Development Facilitation Team (DFT) – Review Comments

DRB Project No: PR-2020-003484 Date: 06/14/2023 Agenda Item: #4 Zone Atlas Page: E-10

Application For: SD-2023-00048 – PRELIMINARY PLAT (DHO)

DRB Project Number: 2020-003484 Hearing Date: **06-14-2023**
 Project: Mojave Ridge Subdivision Agenda Item No: 4

CITY OF ALBUQUERQUE PUBLIC WORKS DEPARTMENT ENGINEERING DEVELOPMENT GROUP		Mo./DAY/YR.	
MOJAVE SUBDIVISION GRADING AND DRAINAGE GRADING PLAN		Mo./DAY/YR.	
DESIGN REVIEW COMMITTEE	CITY ENGINEER APPROVAL	LAST DESIGN UPDATE	
CITY PROJECT NO.	ZONE MAP NO.	SHEET	OF
	E-10	1	3

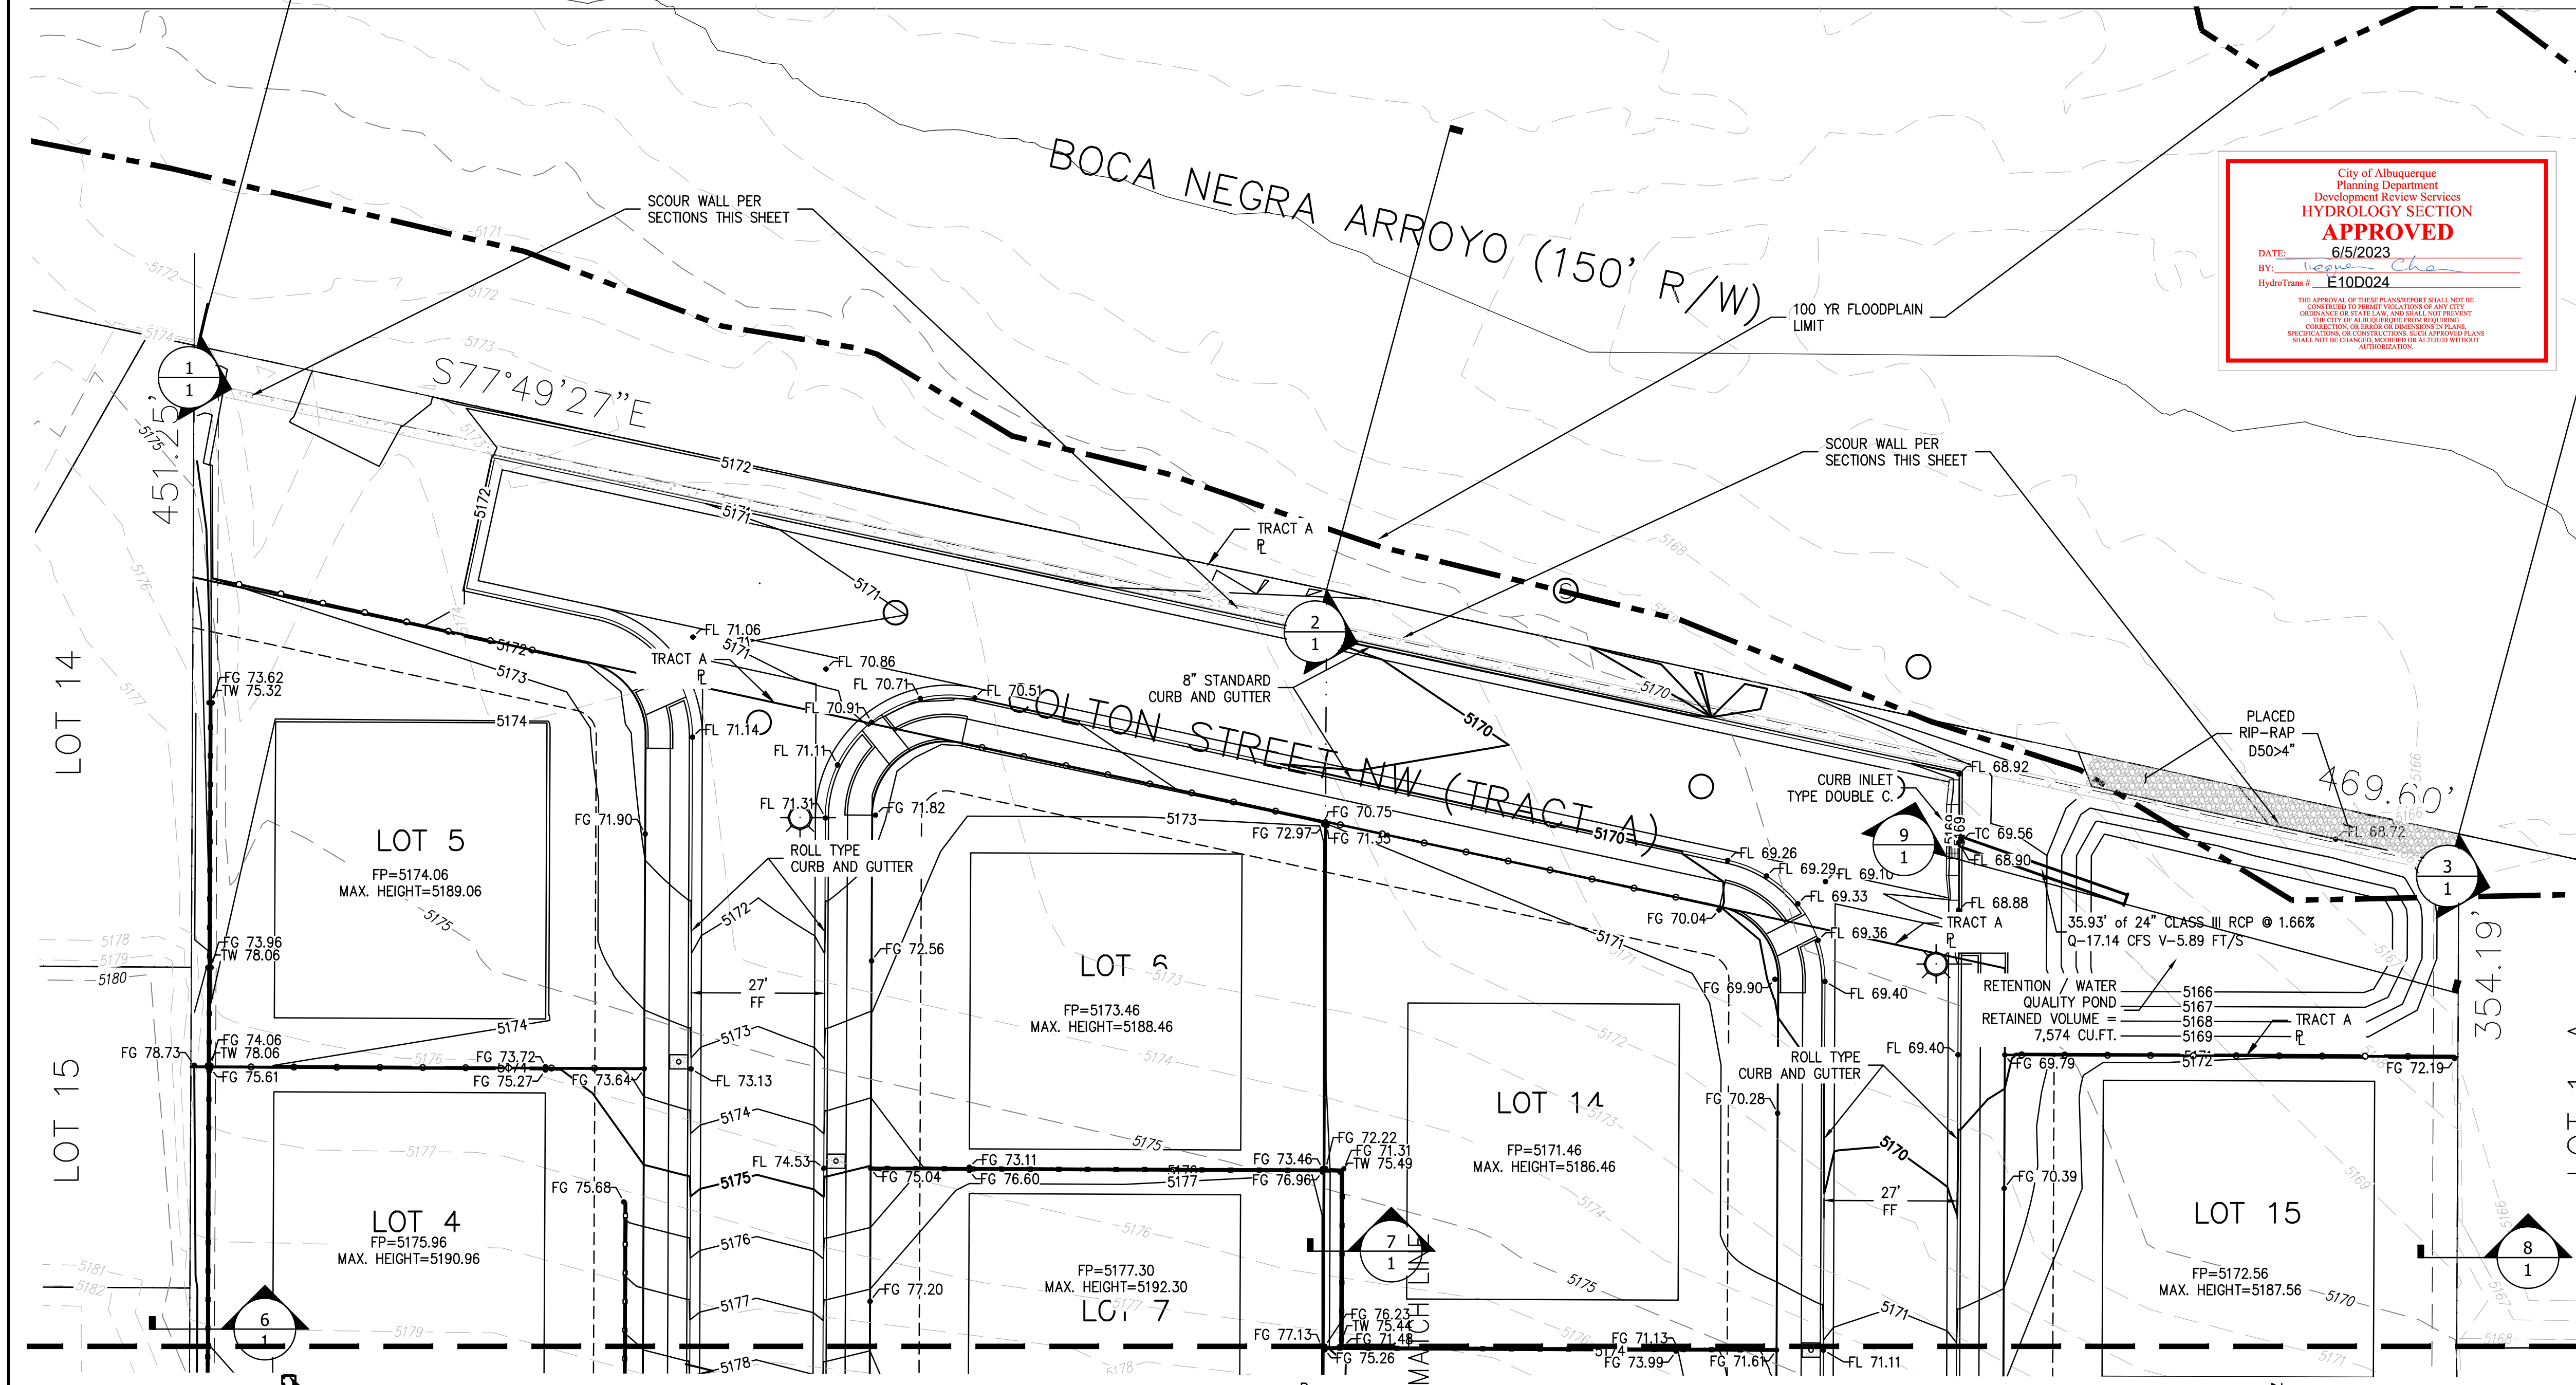
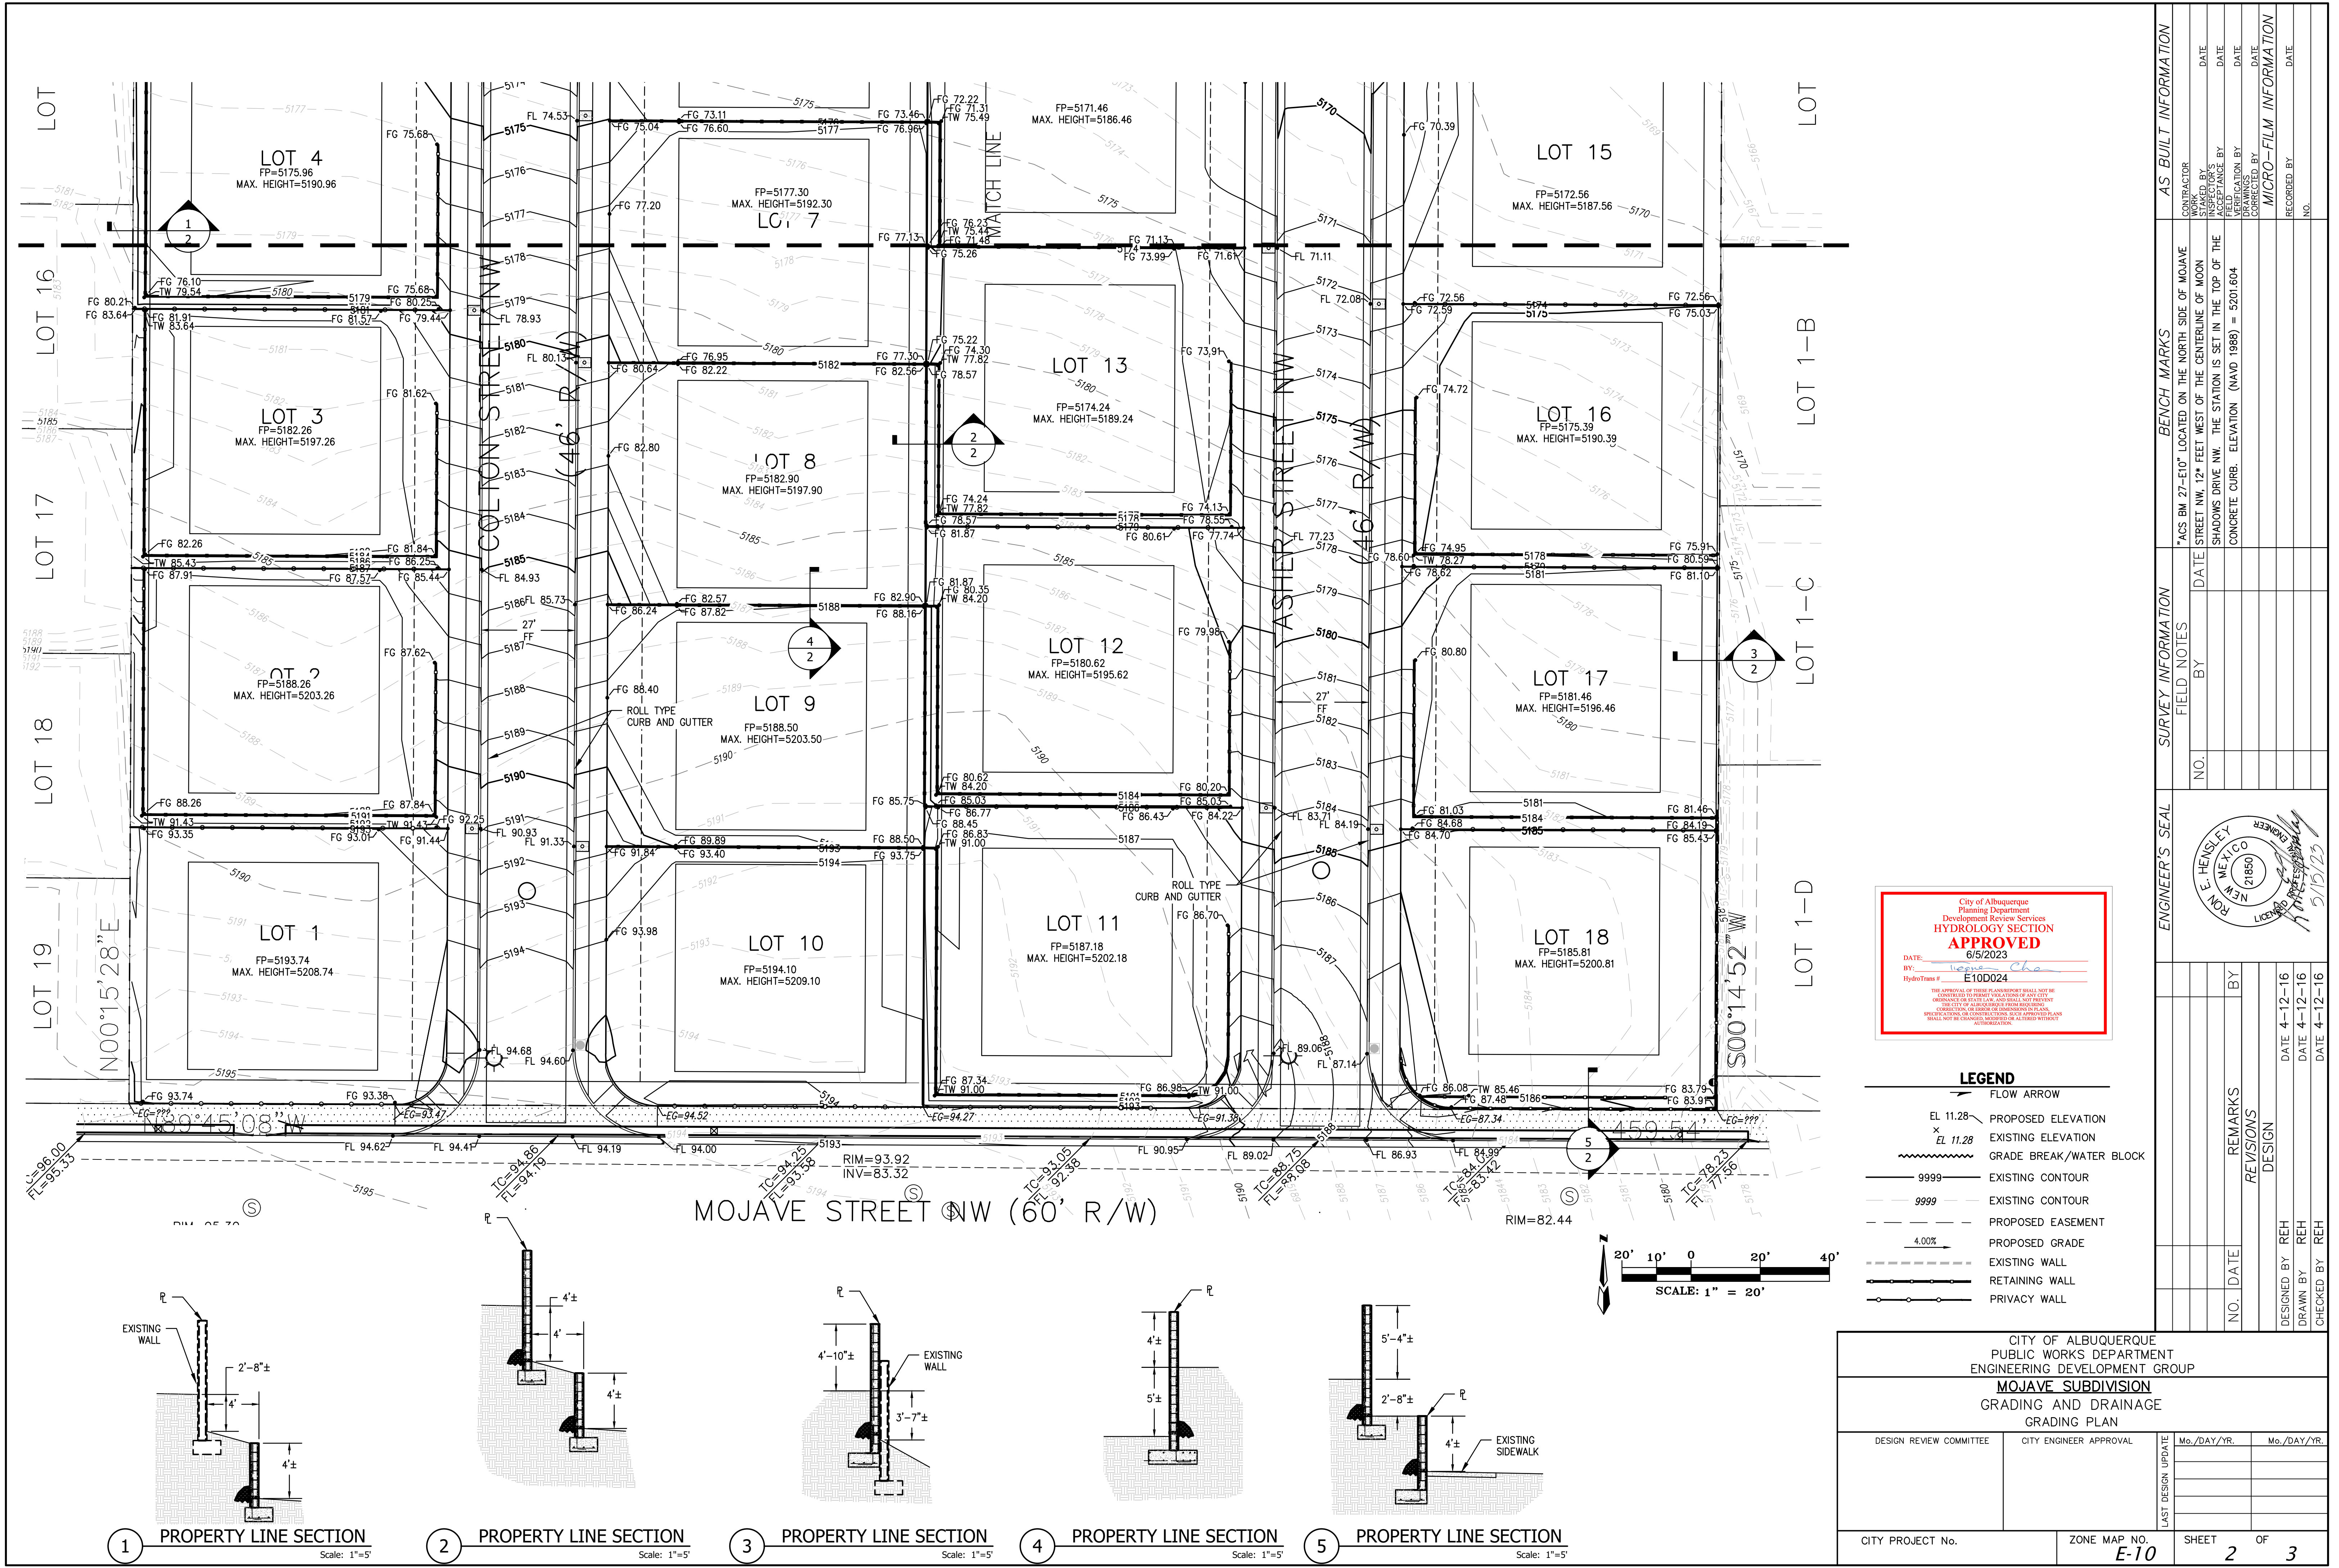
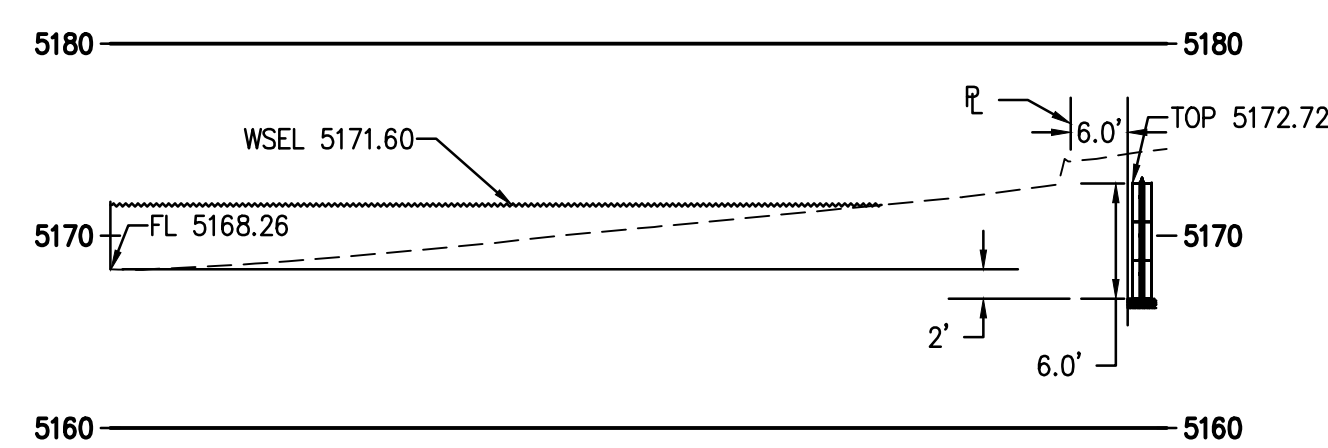
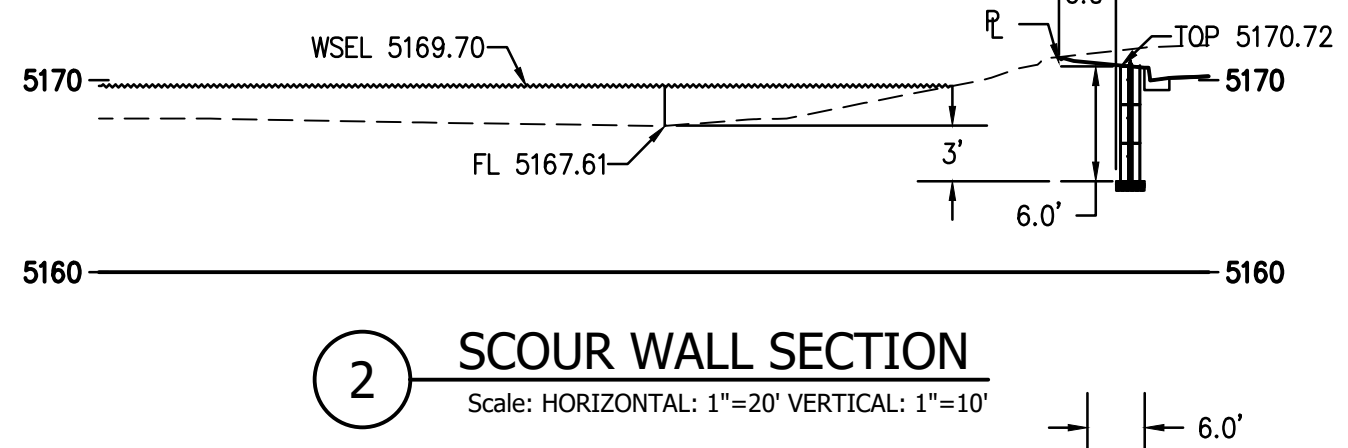
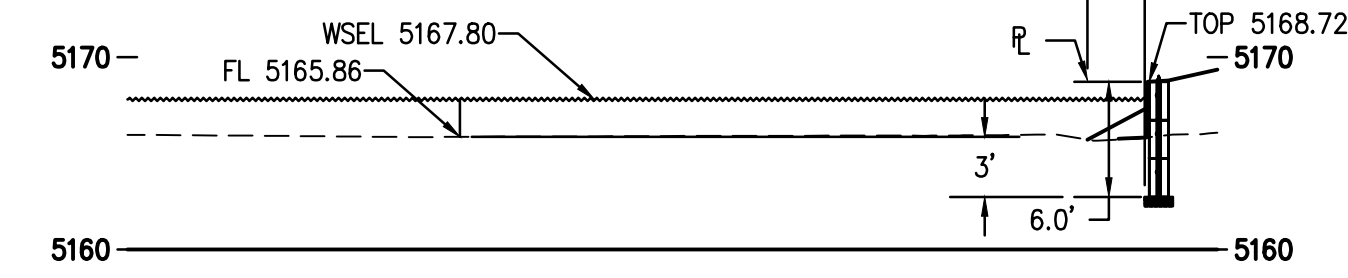
1. I see the Grading and Drainage plan shows Colton St. as a separate tract in order to keep the scour wall out of the ROW. Please ensure this is on the plat that we are approving. No objection.
